Subject: FW: Planning Consultation on: BR/11/14/

APPLICATION NO: BR/11/14/
Registered: 17th January 2014
Site Address: Nyetimber Mazda 33 Chichester Road Bognor Regis PO21 2XH
Grid Reference: 493362 100040
Description of Works: Installation of new external refrigeration condenser, refrigeration pack and 3 no. new a/c units at rear.

**PROPOSED SOUTH WEST ELEVATION**

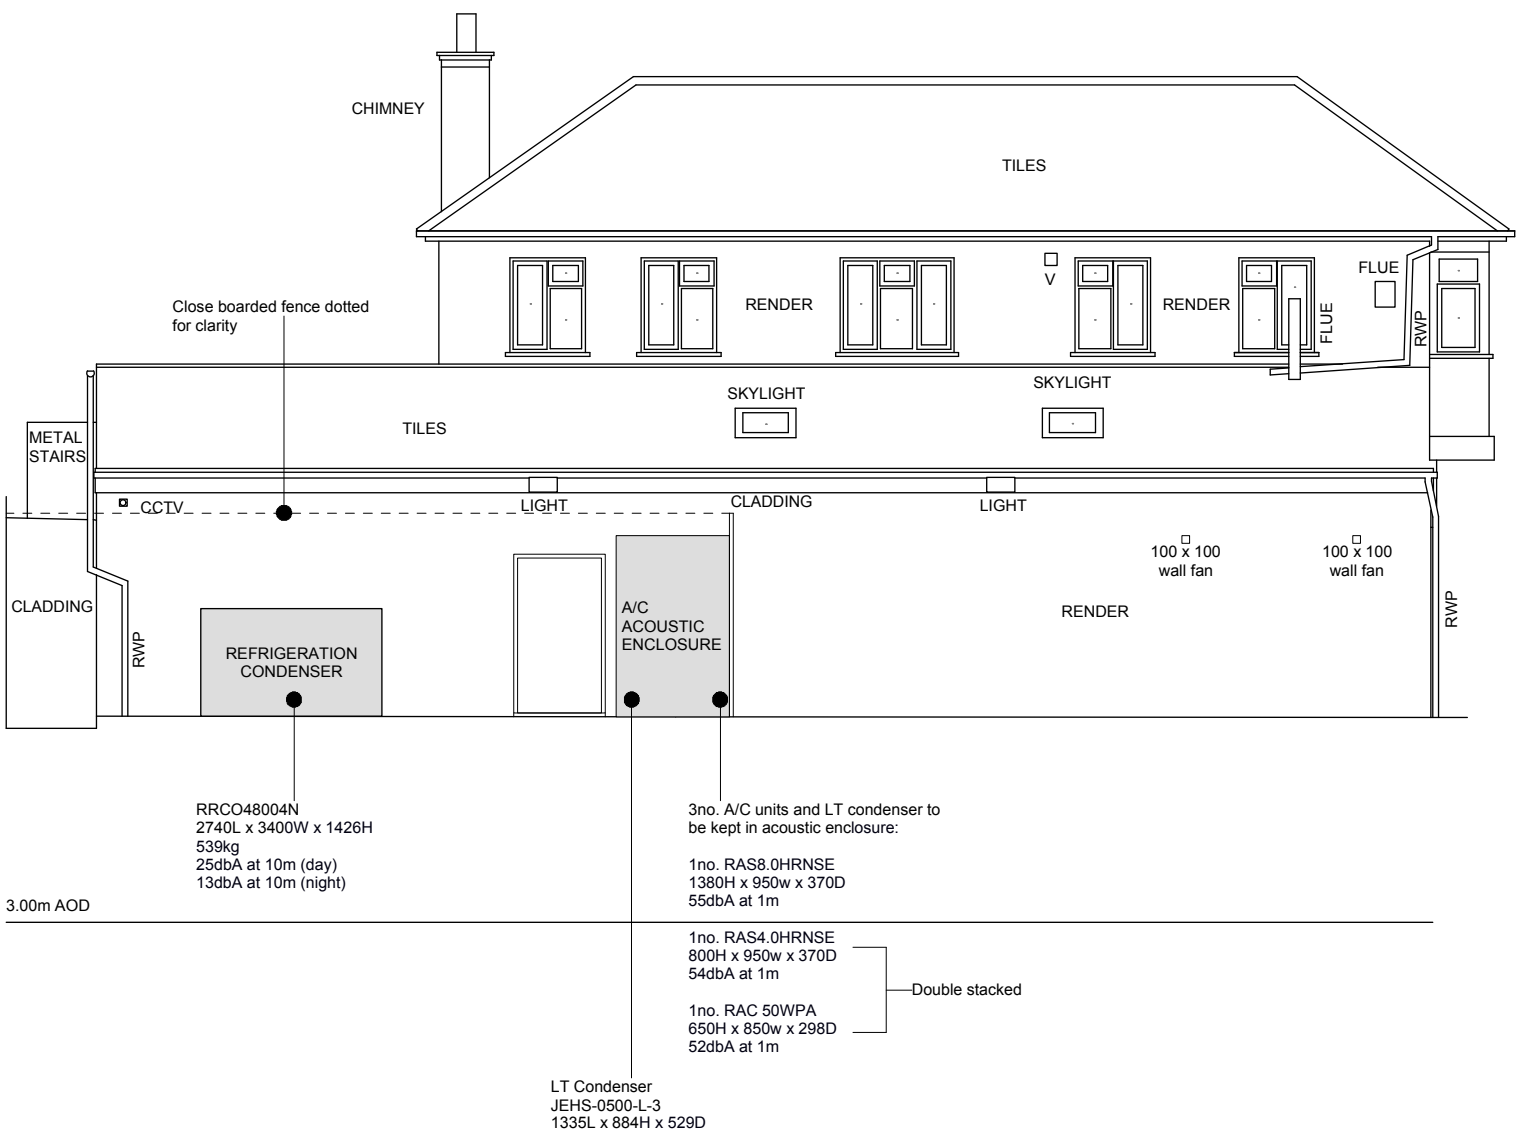
See previous comment in respect of BR/249/13. It is assumed that the adjacent flat may be in separate residential accommodation and have habitable rooms on the façade closest (SW elevation) to the proposed a/c units. It is also assumed that the plant will run 24/7?

The proposed south west elevation plan suggests significant noise may be produced by 3 A/C units, no information is apparent in respect of the attenuation expected to be provided by the acoustic enclosure and the surrounding close boarded fence and the consequent expected noise at the nearest noise sensitive premises cannot be ascertained.

The applicants attention should be drawn to clause 2.3.1 of the attached advice.
